**From:** Roy Talbot  
**Sent:** 24 August 2017 16:34  
**To:** Rachael Collard  
**Subject:** Re: 13 Peartree Farm

Application Reference: 6/2017/1486/VAR

SITE/ROOF PLAN

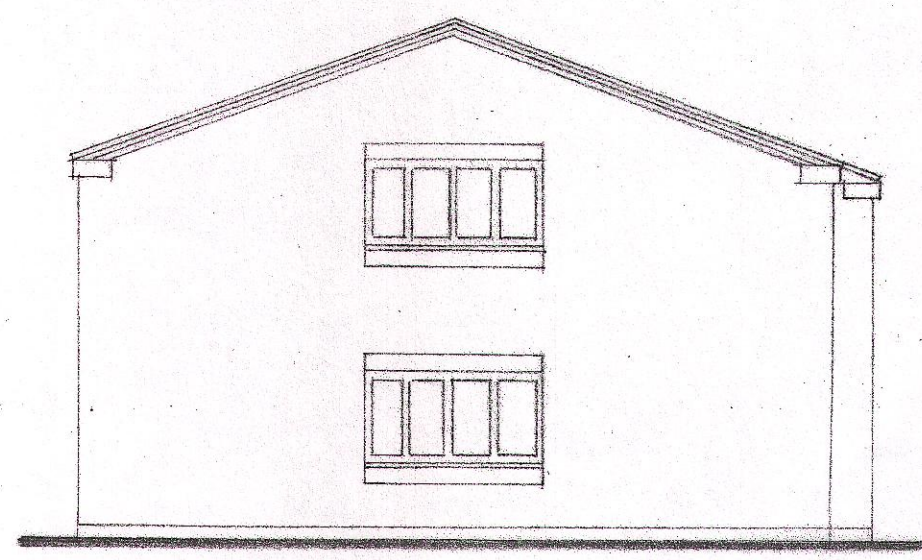
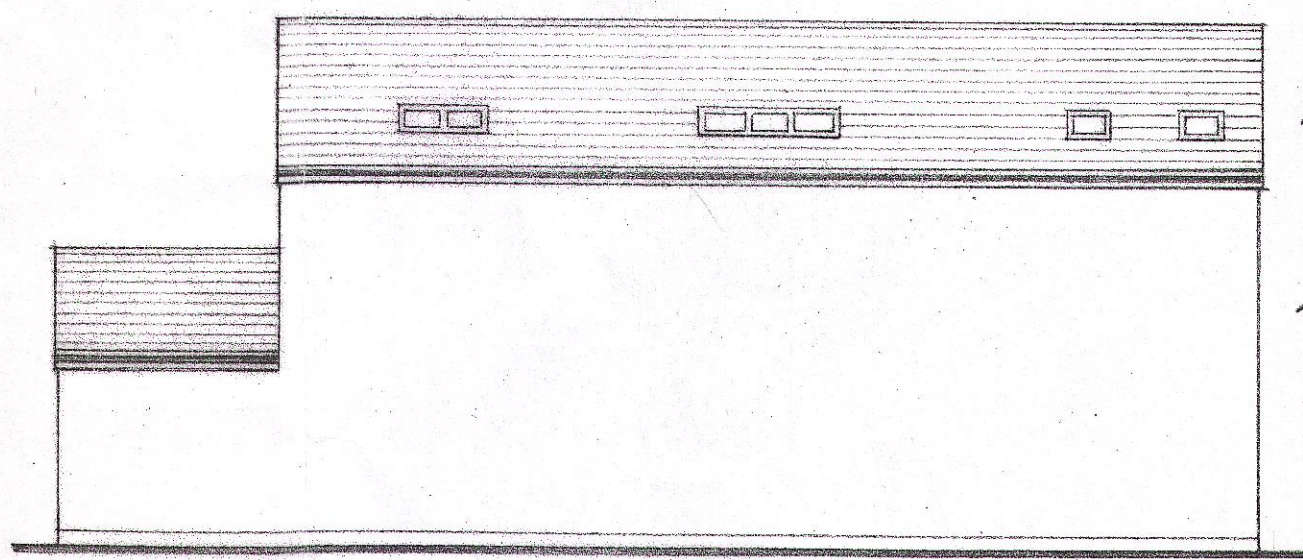
My architect, Joseph Breslin, will look at reducing the proposed increase to the eaves height by over 50% (from 1.45m to 70cm). Although this would result in a finished eaves height of only 3.95m it helps make areas of the upper floor useable. Also, we will remove the additional windows from the upper floor and reinstate a steeper pitched roof, retaining the original 1.5 storey design.
